WEST SUSSEX COUNTY COUNCIL CONSULTATION

TO:	Arun District Council FAO: Simon Davis
FROM:	WSCC - Highways Authority
DATE:	22 March 2021
LOCATION:	Land at Bilsham Road Yapton
SUBJECT:	Y/152/20/RES Approval of reserved matters (appearance, landscaping, layout and scale) following the grant of Y/91/17/OUT for 250 No. dwellings with associated parking, road/footway/ cycleway provision, open space, landscaping, surface water attenuation & ancillary works.
DATE OF SITE VISIT:	n/a
RECOMMENDATION:	More Information
S106 CONTRIBUTION TOTAL:	n/a

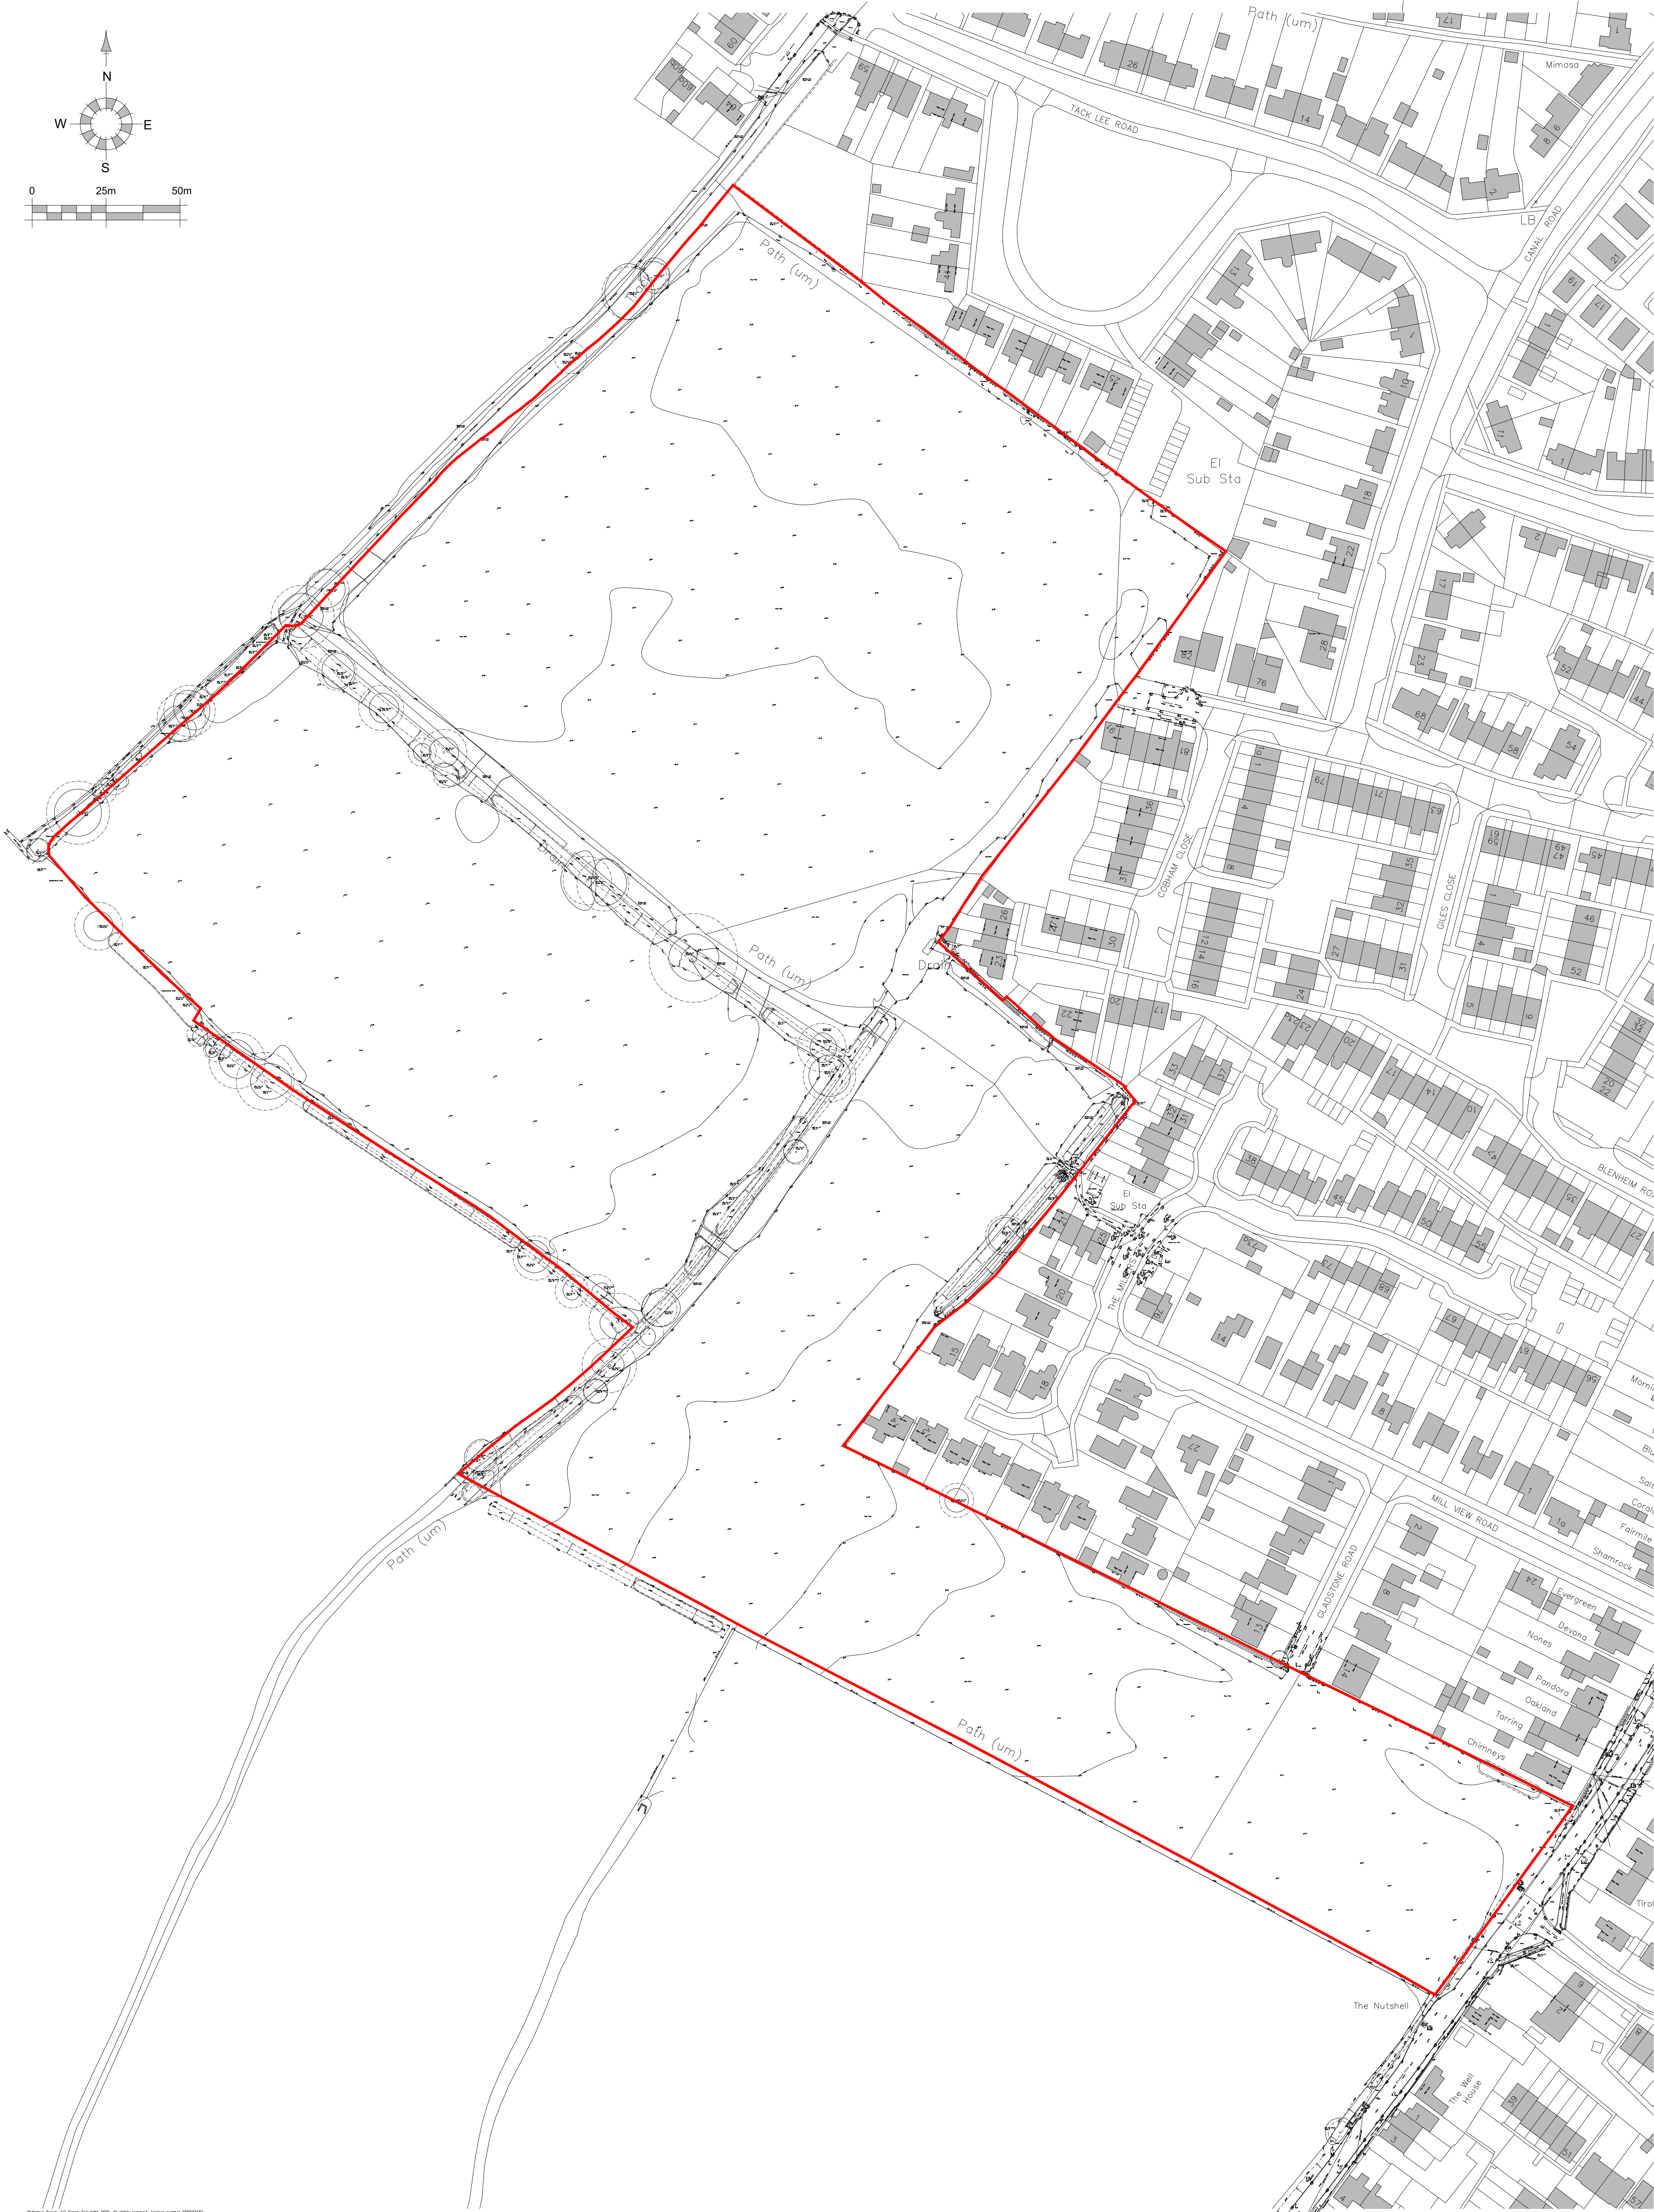
- **Footway outside plots 36 – 41** – outside these plots to the site access on Bilsham Lane there are several short sections of pavement leading to the spine road (Surface Material Layout Sheet Two drawing number 19284 P105.2). It is not apparent as to the rationale for the number of sections of footway in this location and whether they are located in the best places (ie very close to the site access where a dropped kerb/tactile paving crossing is proposed & in align with the ramped section of the raised table traffic calming features). The applicant should provide clarification as to the rationale and the wider issue of where they intend to provide crossing facilities and in what form across the site's spine road.

- **Secondary street by plots 93-96** – the design and materials used for this street appears to contradict the design approach for all other roads.

On this street a footway is provided each side of a block work carriageway. The Highway Authority preference is for the design approach to be tarmac and a footway on both sides for a traditional road design and only provide a block work carriageway treatment in shared surface areas, as proposed for the rest of the site. Therefore, the Highway Authority would look for this street to be changed to a tarmac surface and only use block work to help distinguish shared surface areas.

- **Extent of footway** – there are two areas where the extent of footway should be extended slightly to ensure it safely passes the proposed traffic calming features at the entrance of shared surface areas. The footways around plots 89 and 157 should be extended slightly so they extend beyond the proposed traffic calming feature.

- **Nature of vehicle access plots 144-146 and 203-205** – these access points are currently designed as bell mouth junctions but given the low number of vehicle movements consideration should be given to designing them as standard residential vehicle crossovers and a continuous footway provided along the frontage.
